Tree value and root investigations for trees adjacent to the A3

RHS Wisley, Surrey

RHS REP10-xxx - Appendix 5 - Barrell Tree Consultancy - Report - Tree value and root investigations for trees adjacent to the A3 2 June 2020_

2nd June 2020

4.4 Root Morphology – T184 Giant Redwood

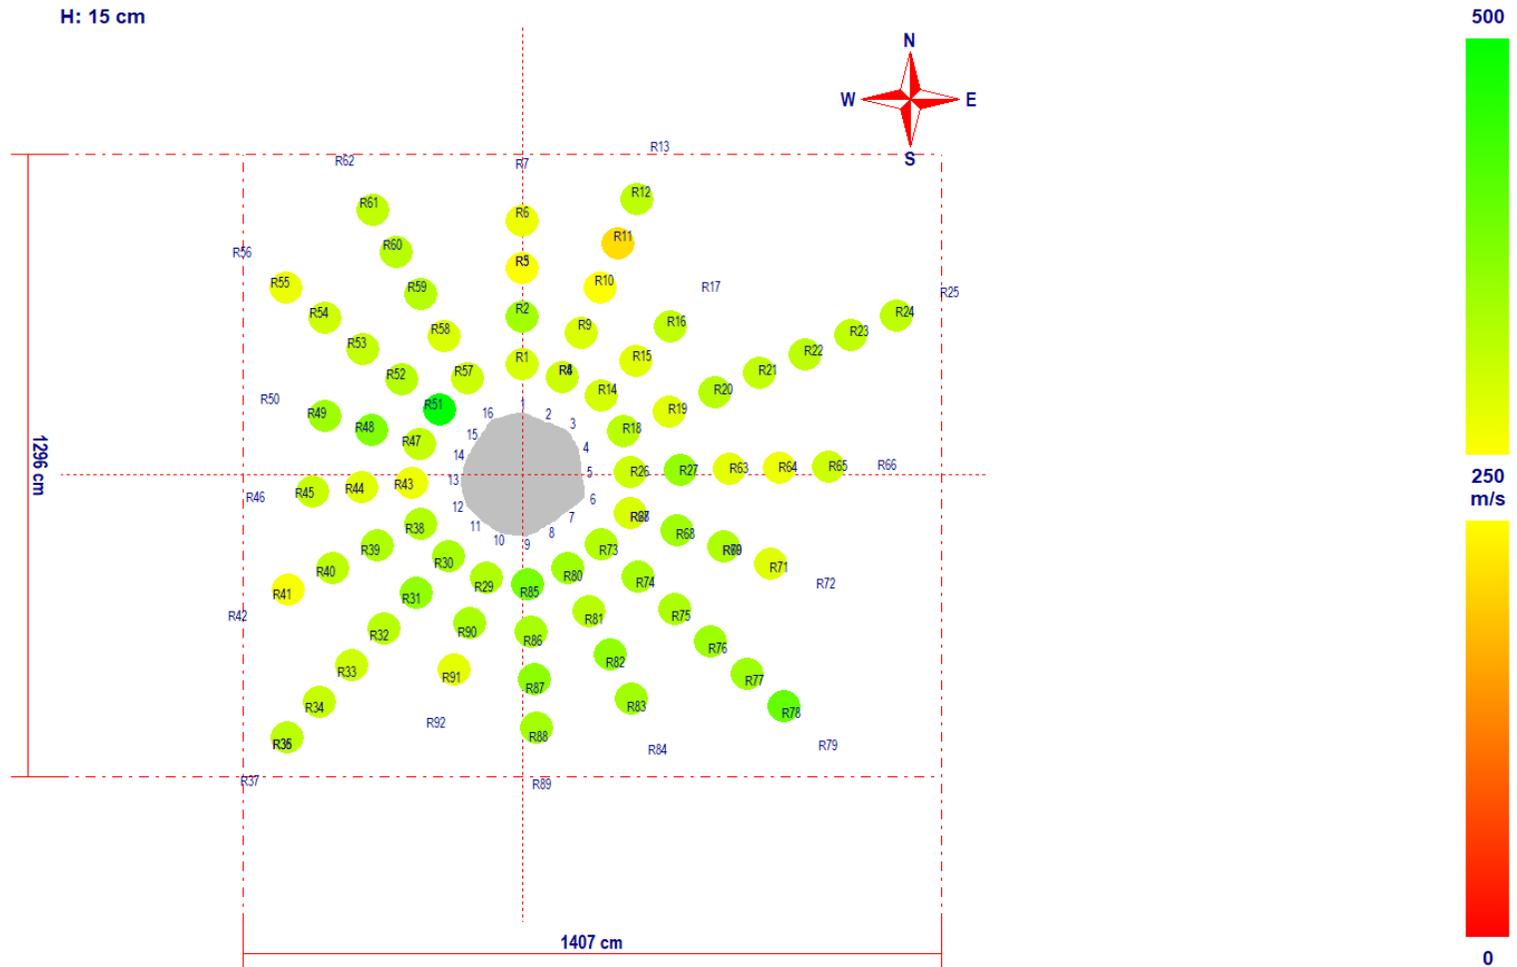
At T184, I located an area roughly to the west of the trunk, and at 8.5m from its centre, that was free from other nearby large trees (Figure 2), and excavated a trench that is approximately shown on an extract of the root morphology graphic (Figure 3). At this point, the trench was excavated perpendicular to the radius from the tree about 2m in length, 0.5m in width, and 1m depth (Figure 4). Within that trench at about 30–40cm below ground level, I uncovered three substantial roots that were measured at about 7–10cm diameter (Figure 5). I confirmed that these were alive by noting the bark was firmly attached and that they were likely to be from T184 because of the red colour of the bark and wood beneath, a known root characteristic of this species. I also noted smaller fibrous roots at the bottom of the pit at about 1m depth, that I also identified as likely to be from the subject tree (Figure 6). I did not take samples for laboratory confirmation of the species, but this could be easily done if the findings are disputed. The trench was filled in following the excavation, but it would be possible to easily open it up again if any of my observations needed to be verified.

In the absence of supporting explanations or a published record of any verification process, I decided to check the results shown on the graphic in Figure 3 by excavating in an area where the graphic indicated there would be no significant roots of greater than 2.5cm diameter. This location is shown on Figures 3 and 4, and is 8.5m from the centre of the tree, about 2.5m from the last indicated location on the graphic of any significant roots in excess of 2.5cm. The reason for choosing this location was to check the results shown in the graphic.

As can be clearly seen from Figures 4, 5, and 6, three roots of 7–10cm were uncovered, which is a size three to four times larger than the minimum size claimed to be identified by this technology. The Arboradix investigation did not identify these roots. Although I have only checked one tree, the unreliability of the data was so startling that it must throw into significant doubt the data for the rest of the trees. This simple investigation has confirmed that the results shown in this graphic, and possibly all the other graphics, are not reliable and cannot be credibly used as the basis for advising on any adverse impact on any of the trees without further investigations.
